DEVELOPMENT REVIEW BOARD  
TRANSPORTATION DEVELOPMENT

DRB Project Number: 1000111  
Altura Complex

SUBJECT: Preliminary/ Final Plat

Application Number: 18DRB-70097

PLAT OF TRACT B1 AND B2 ALTURA COMPLEX WITHIN SECTION 11, TOWNSHIP 10 NORTH, RANGE 3 EAST, NEW MEXICO PRINCIPAL MERIDIAN CITY OF ALBUQUERQUE BERNALILLO COUNTY, NEW MEXICO JULY 2018

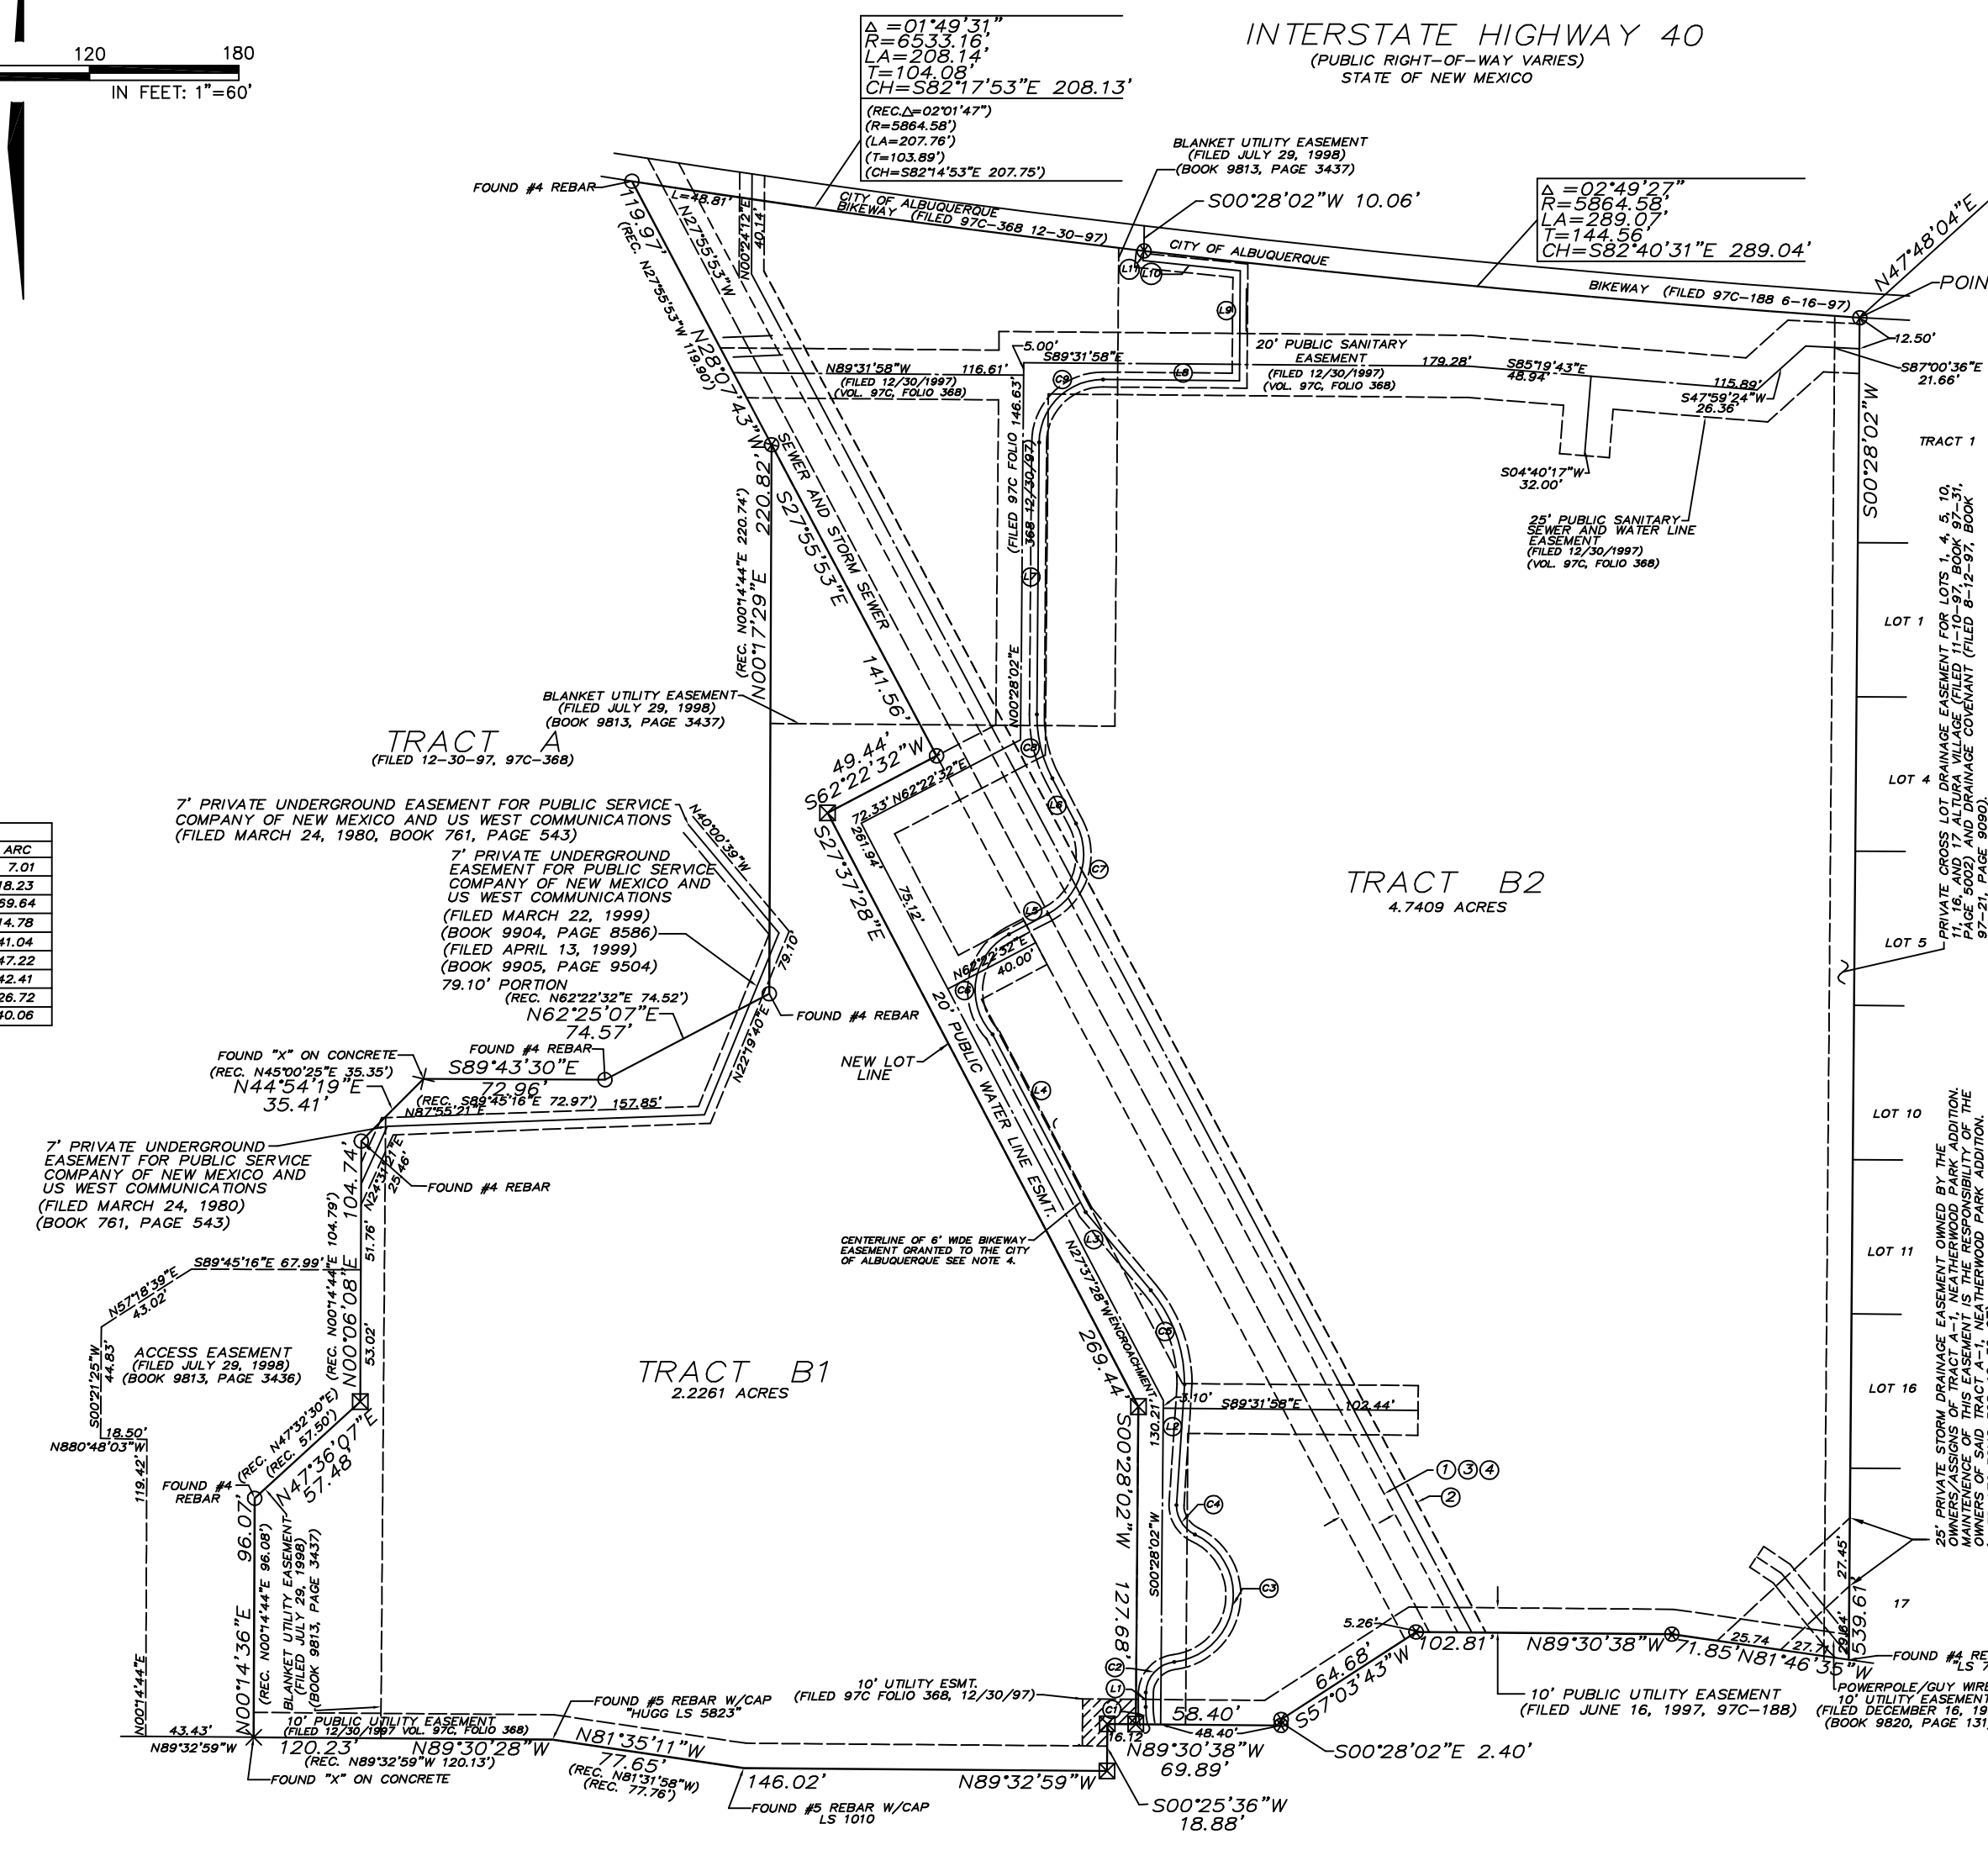
1. Provide a shared access easement between Lots B1 and B2.
2. For final plat, any access easements need to be shown with all beneficiaries and maintenance responsibilities listed.

- A private cross lot drainage easement is required with Maintenance and Beneficiary.

- The submitted plat does not have surveyor's signature which is required.
- Per sketch plat comments made January 24<sup>th</sup> – The entire bike trail easement should be shown. Also the note about the bike trail states "See Note 4" which refers to a 20' storm drainage and public utility easement?
- Per Sketch Plat comments – shared access and parking easement/agreement required prior to plat sign off.
- The note about solar has some writing on top that should be removed so it is legible.

↳ owner working on agreement
